DEVELOPMENT REVIEW BOARD
TRANSPORTATION DEVELOPMENT

DRB Project Number: 2019-002184
Guardian Storage at Osuna

SUBJECT: Site Plan

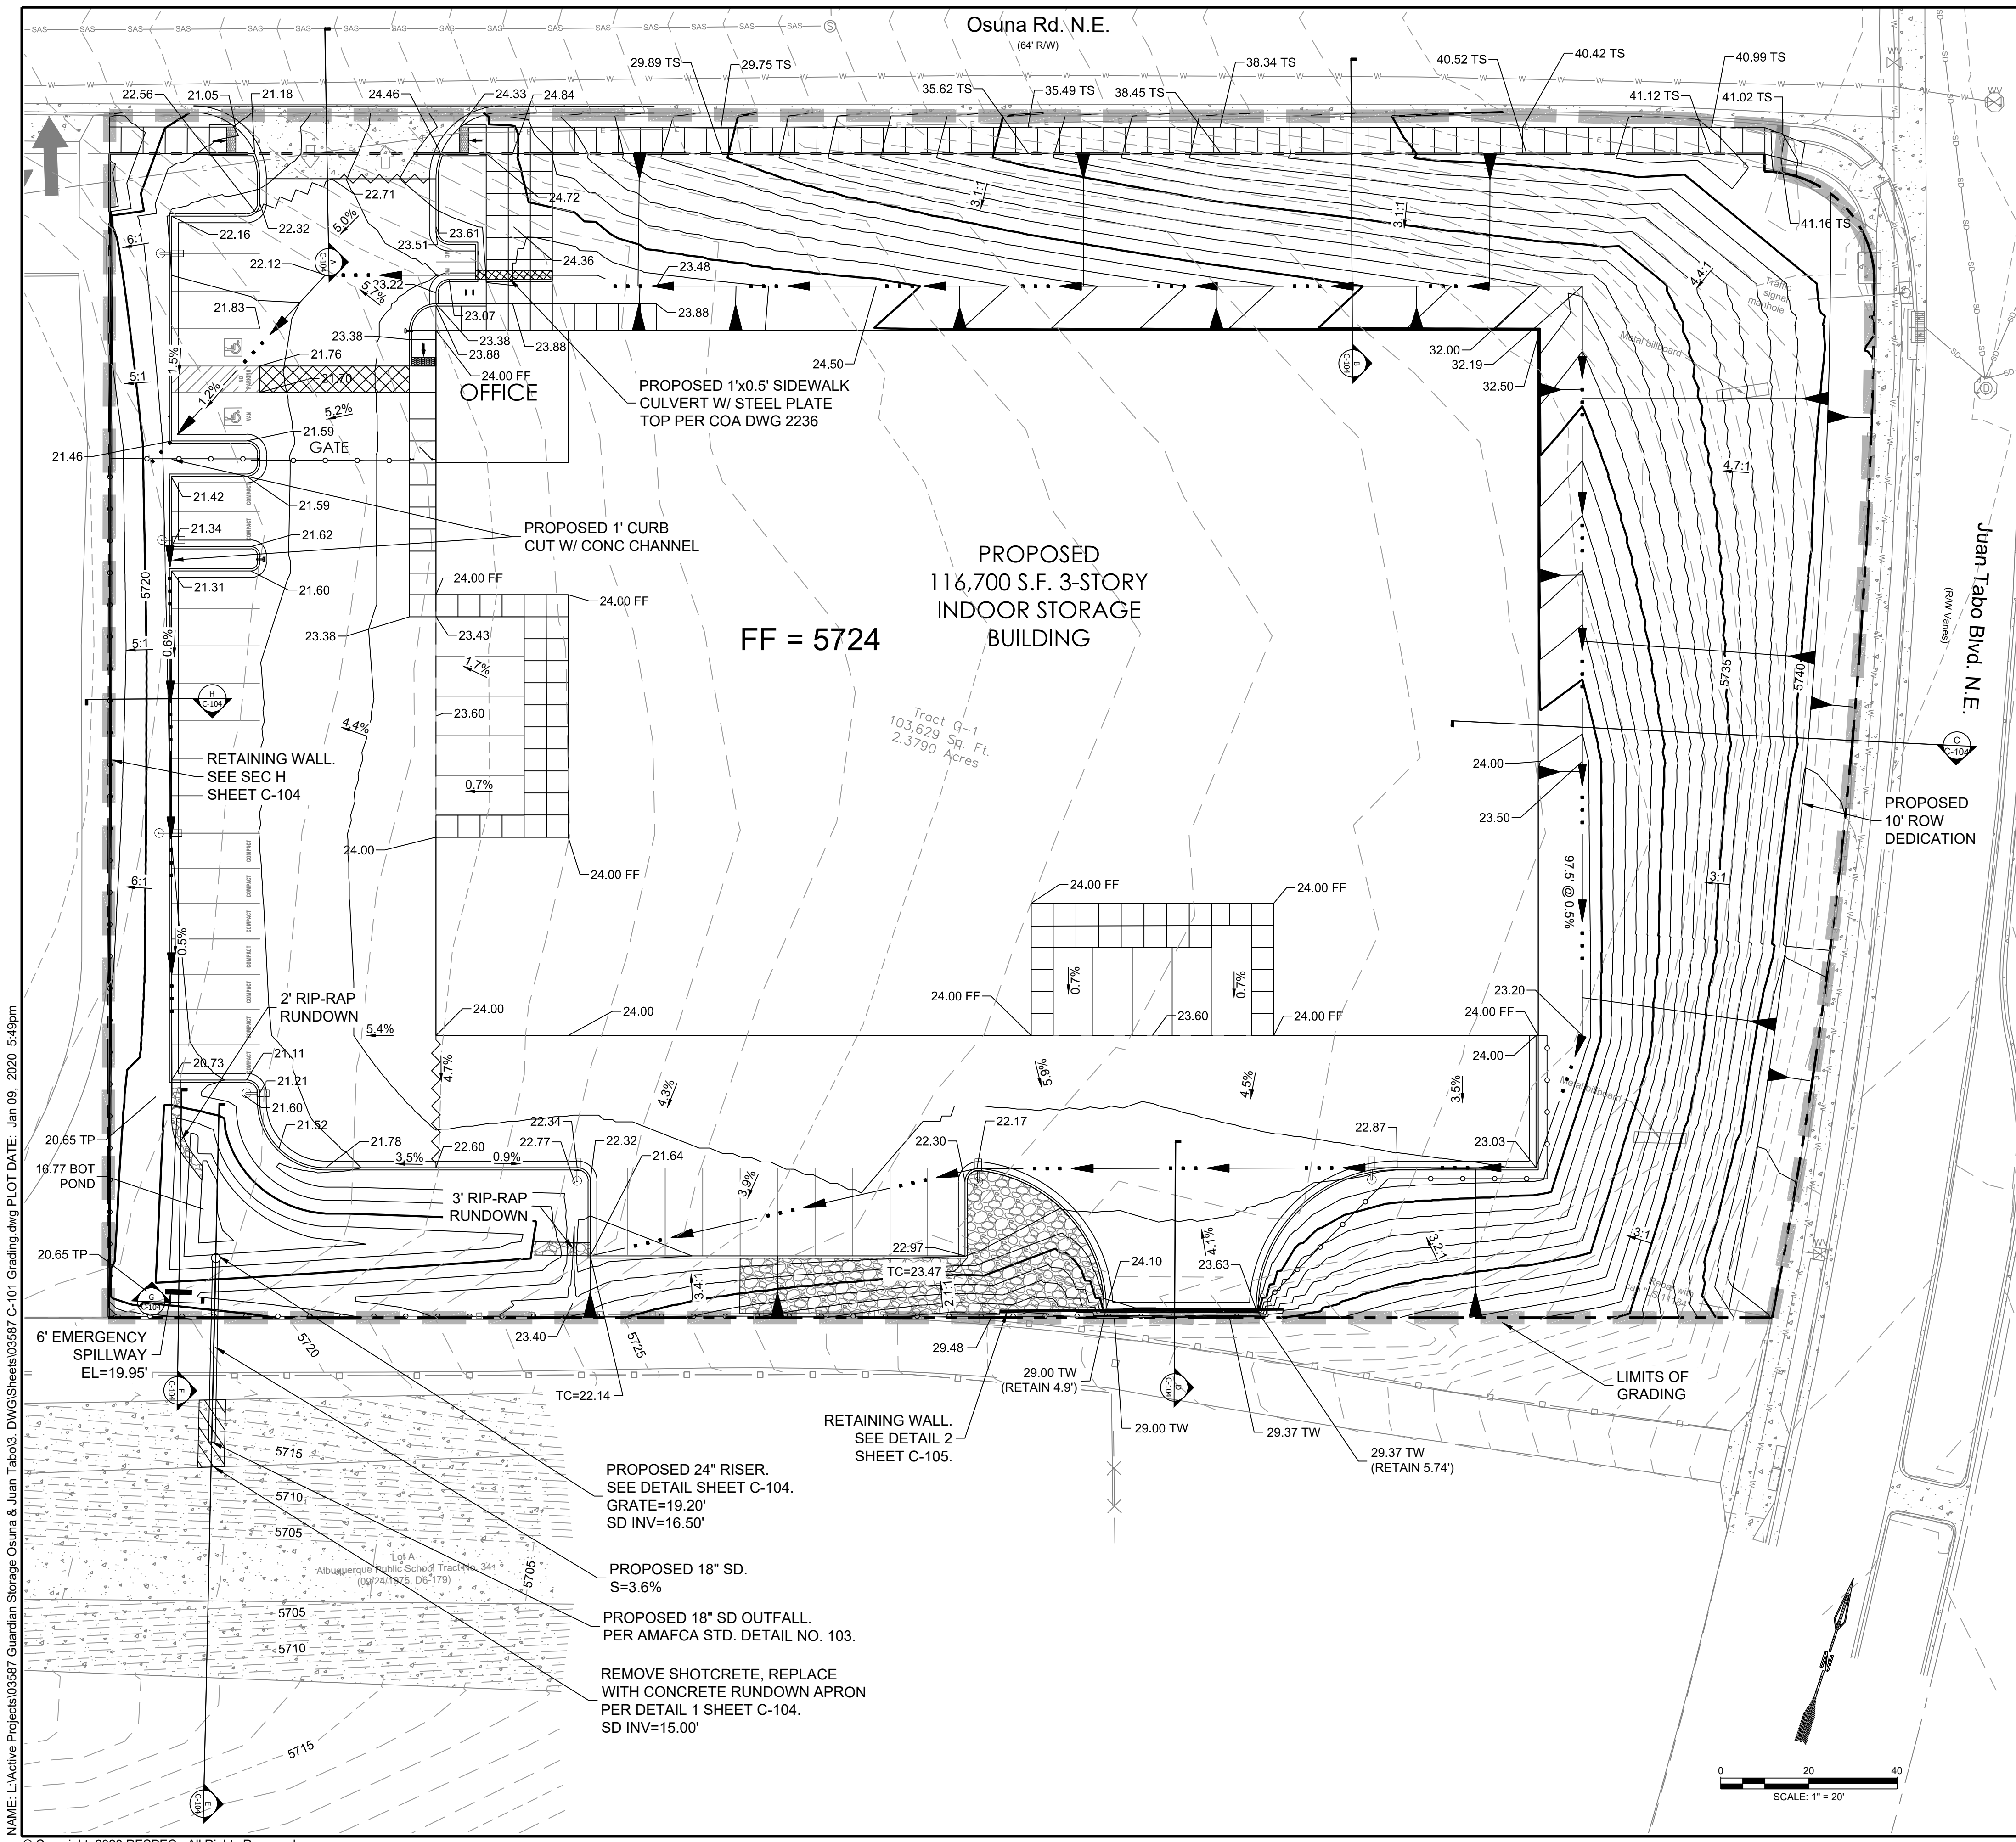
1. Along Juan Tabo Blvd., it is requested to change the 10-foot sidewalk easement to 10-foot of dedicated right-of-way. Therefore, a platting action is required.

5. If curb does not separate parking spaces from sidewalk, provide parking bumpers.
6. Provide cross-section for new sidewalk along Osuna Road NE.
7. Receive approval from Fire Marshall.

4 SIDEWALK RAMP DETAIL
SCALE: NTS

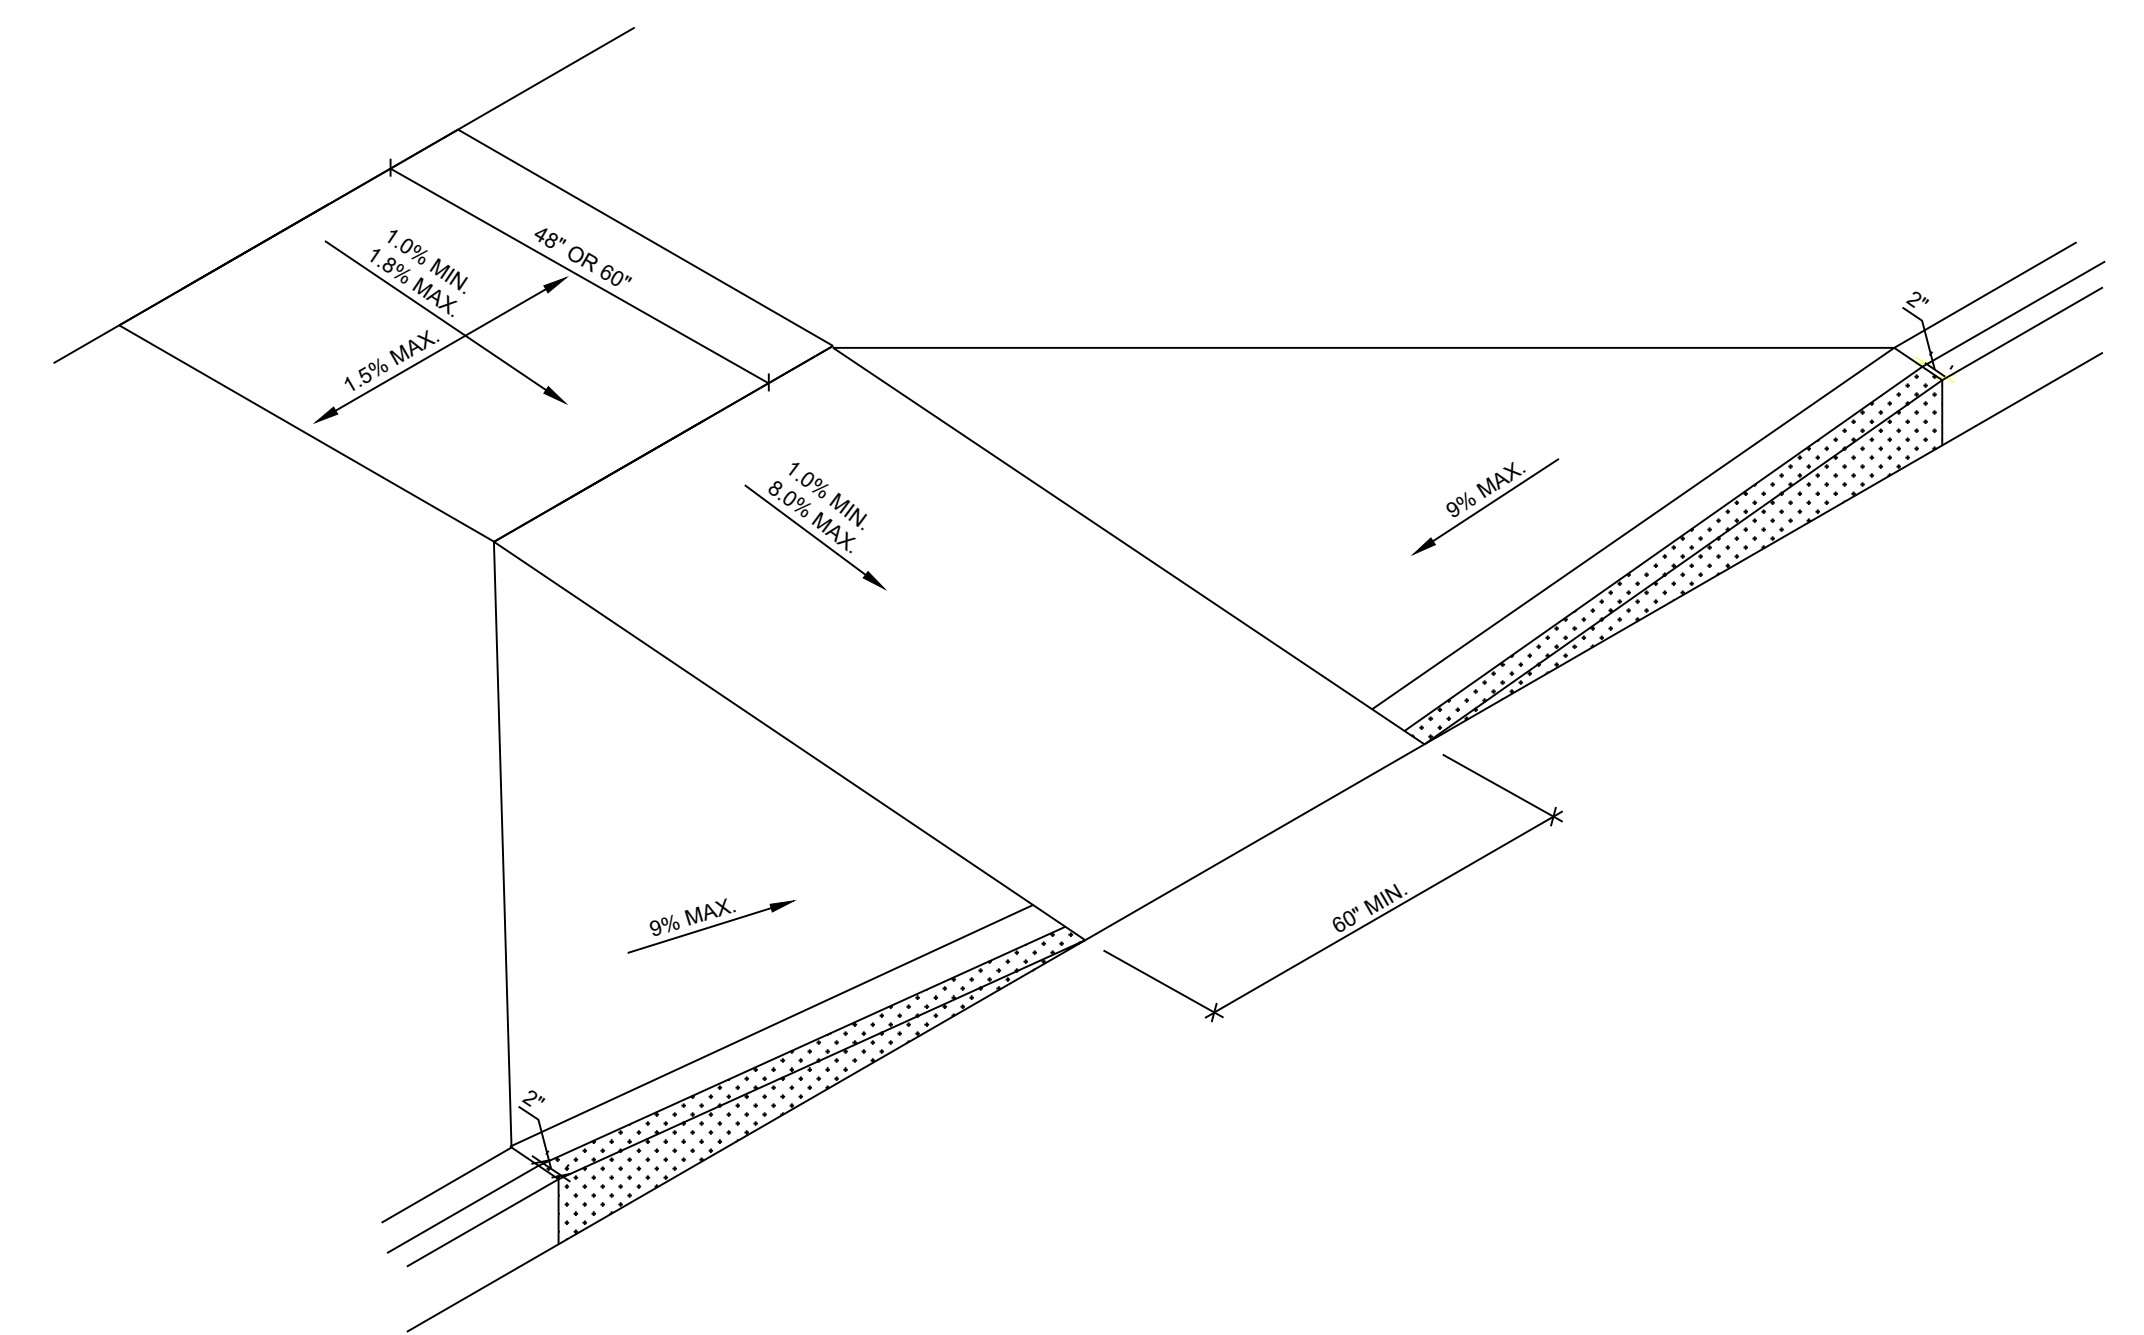
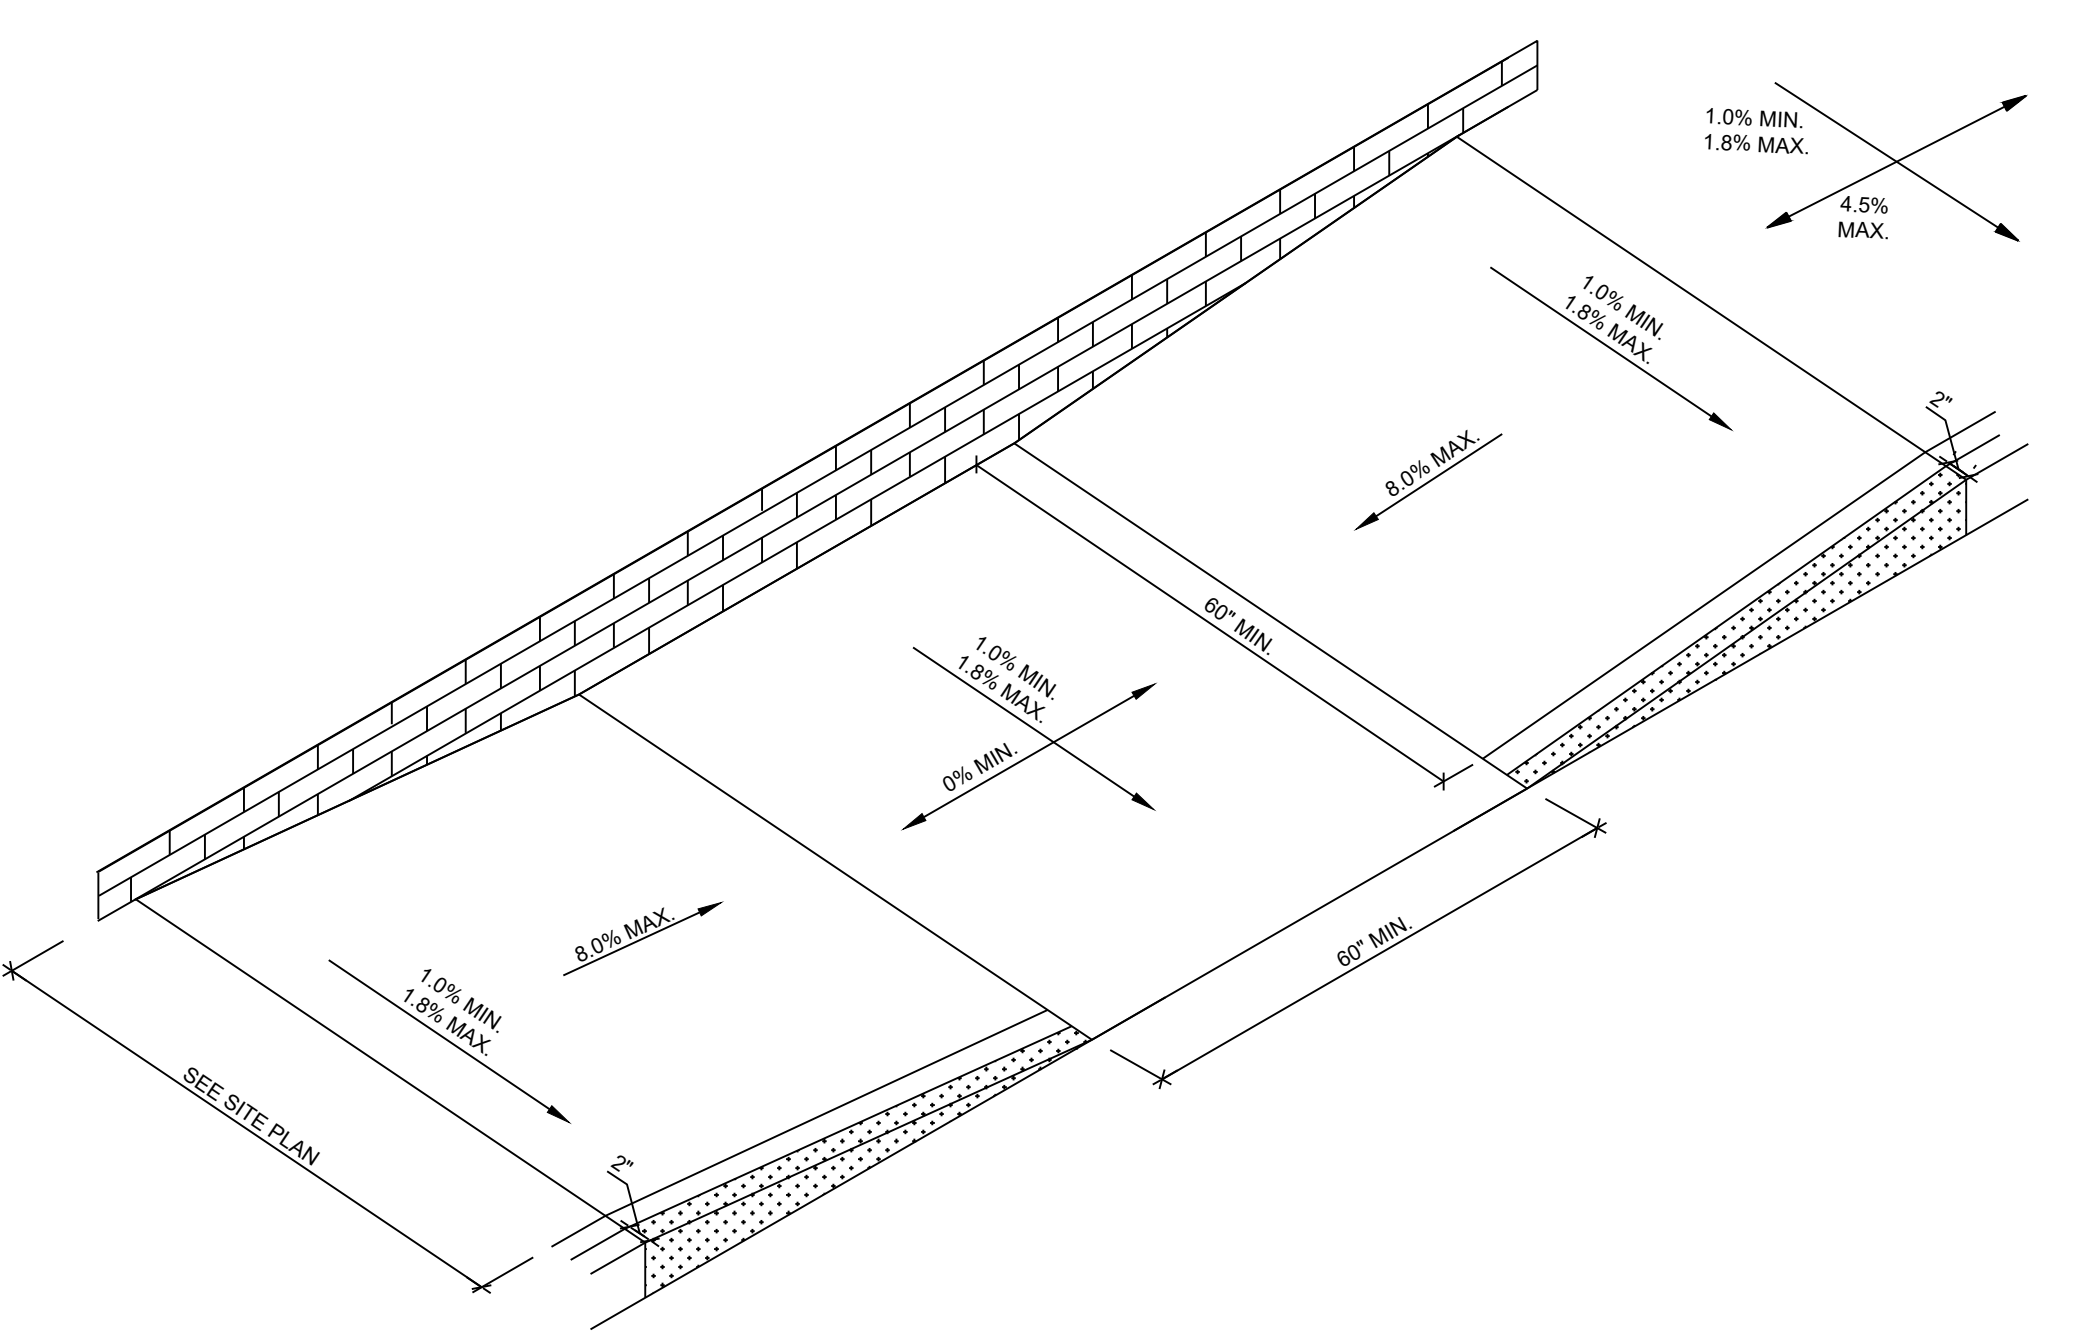
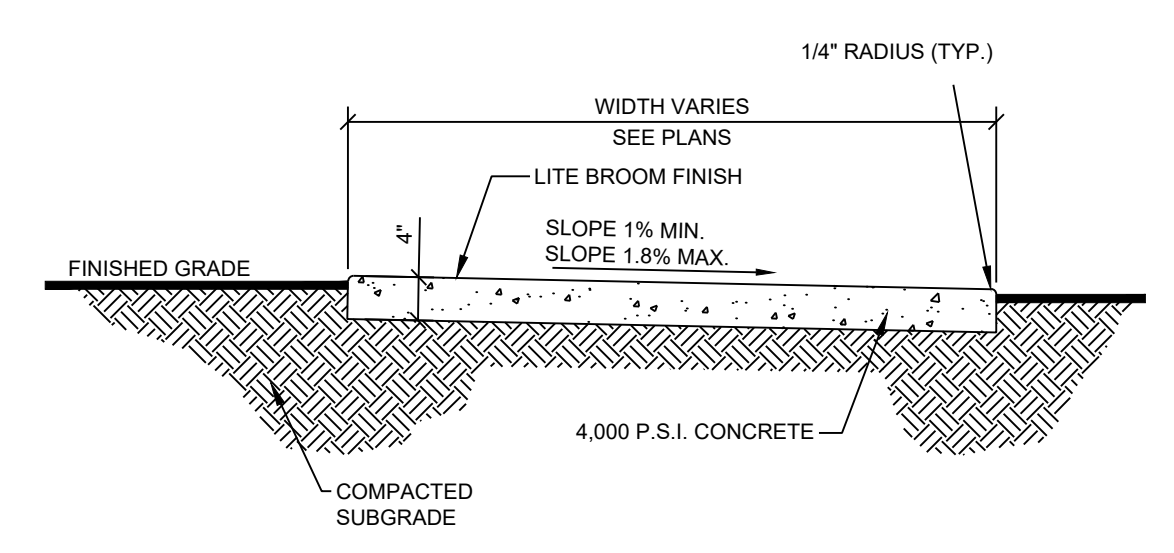
2. Provide curb, curb ramp, and sidewalk details. Sidewalk detail shall show a maximum 2% cross-slope.
3. Dimension parking islands.
4. Provide signage details for the handicapped sign and motorcycle sign. On site plan, show existing and proposed sidewalk widths as well as distance from curb to property line. A minimum 4-foot wide sidewalk is required. The ADA accessible parking sign must have the required language per 66-7-352.4C NMSA 1978 "**Violators Are Subject to a Fine and/or Towing.**" If that language is present it is not visible in the detail.
